CITY OF PORTLAND

This is to certify that Jimino Jerry L/homeowner has permission to Construct a 16x6 porch in front of house replace existing porch. AT 1413 Riverside St 370 A038001

**Dept:** Zoning      **Status:** Approved with Conditions      **Reviewer:** Ann Machado      **Approval Date:** 05/15/2006

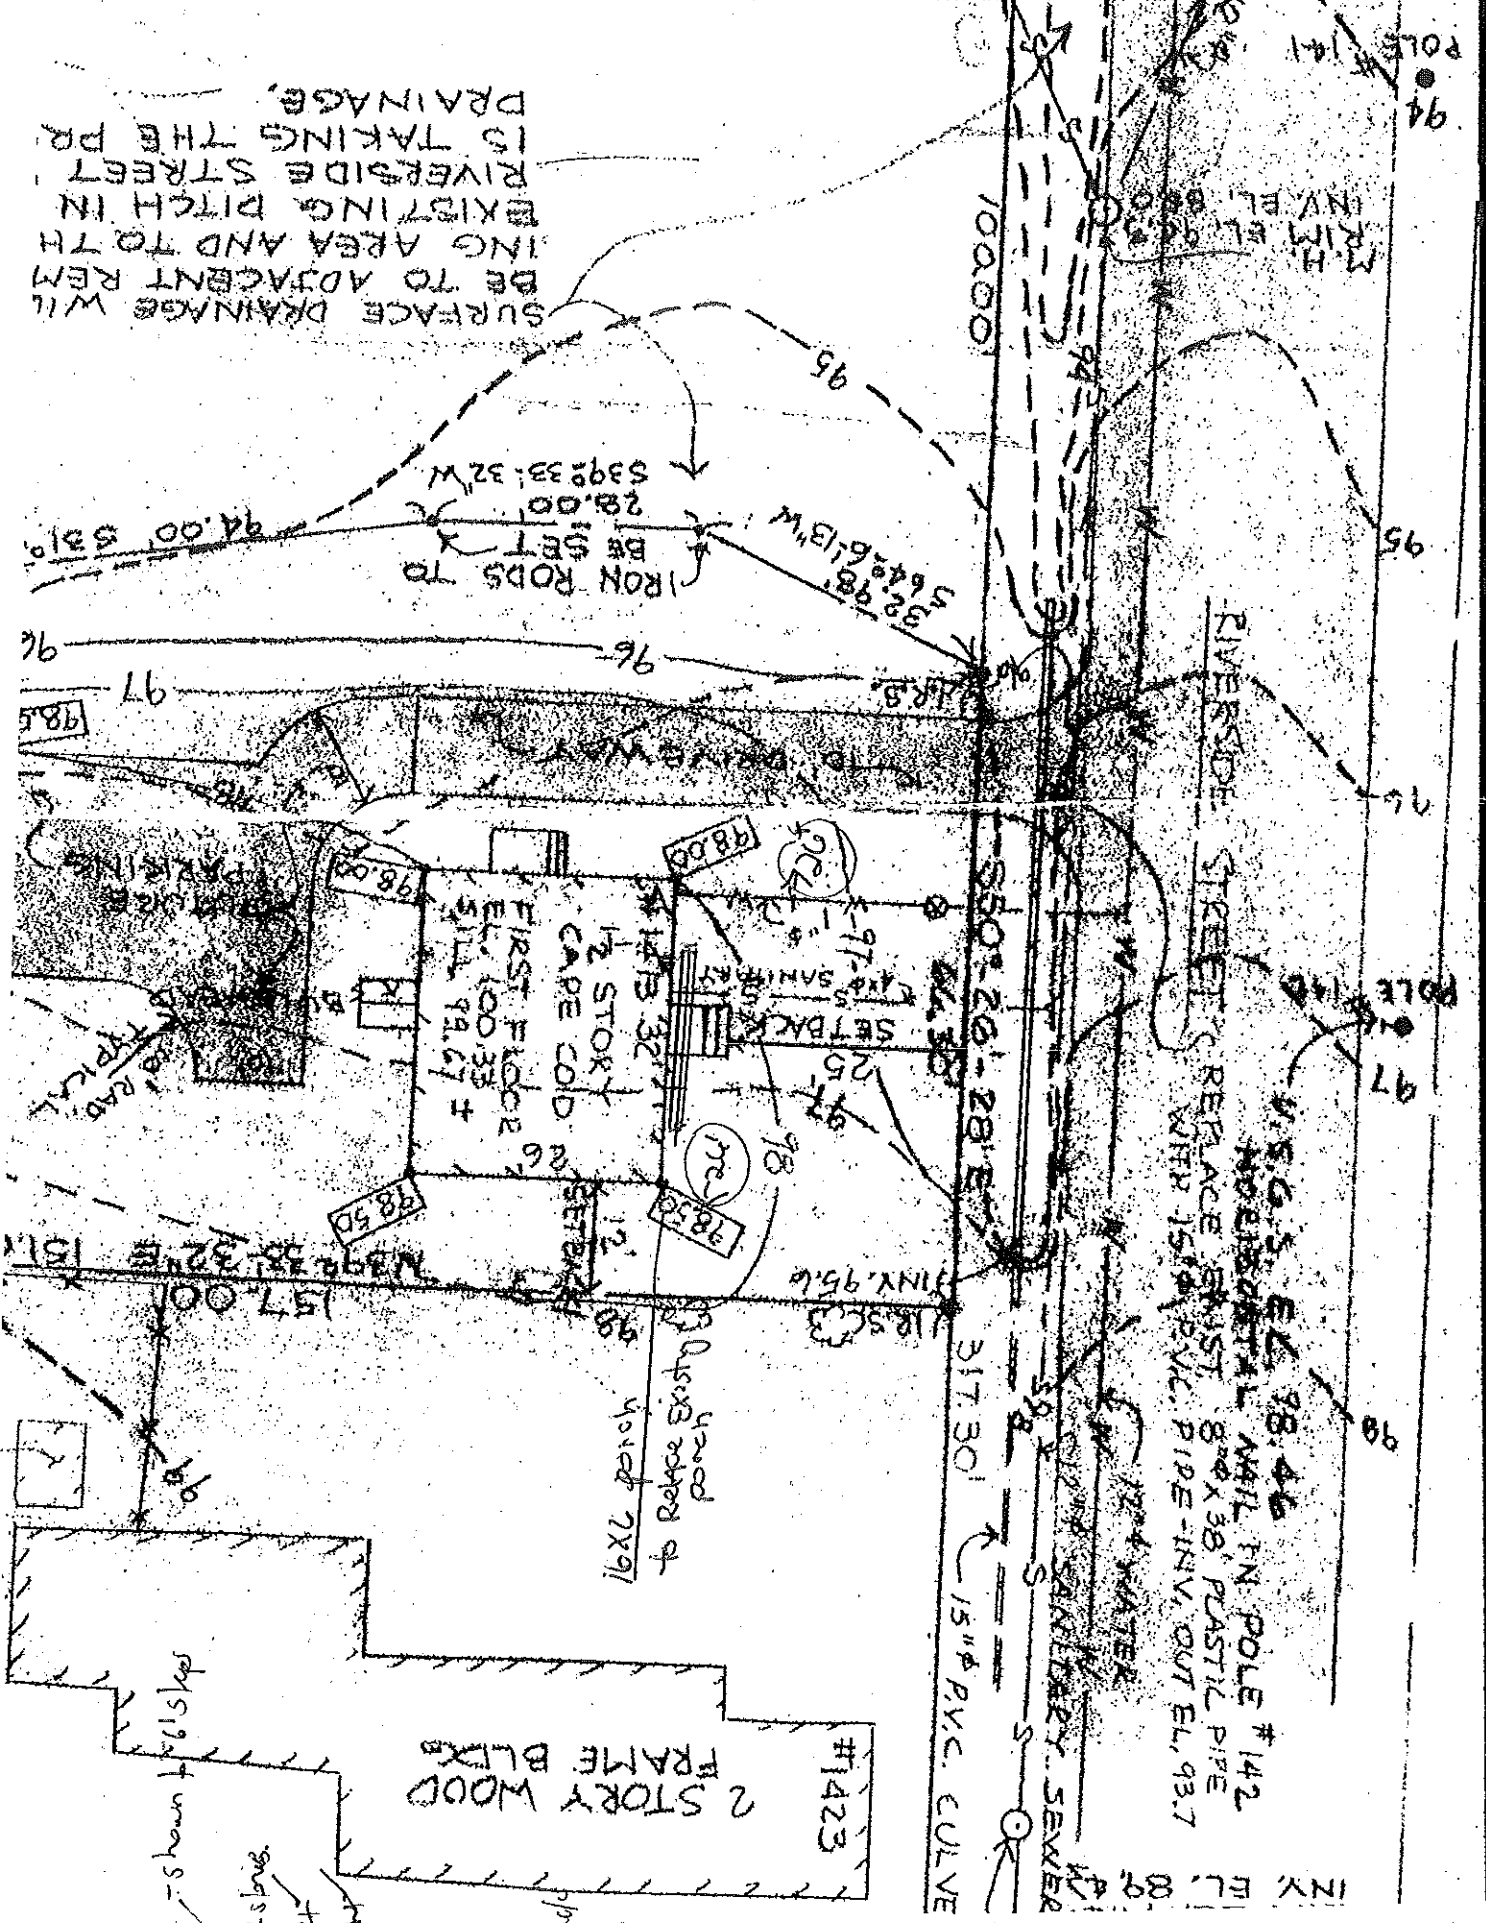
**Note:** New front porch is within front setback, but the steps are not. Ok under section 14-425 - steps are 10s.f.      **Ok to Issue:**
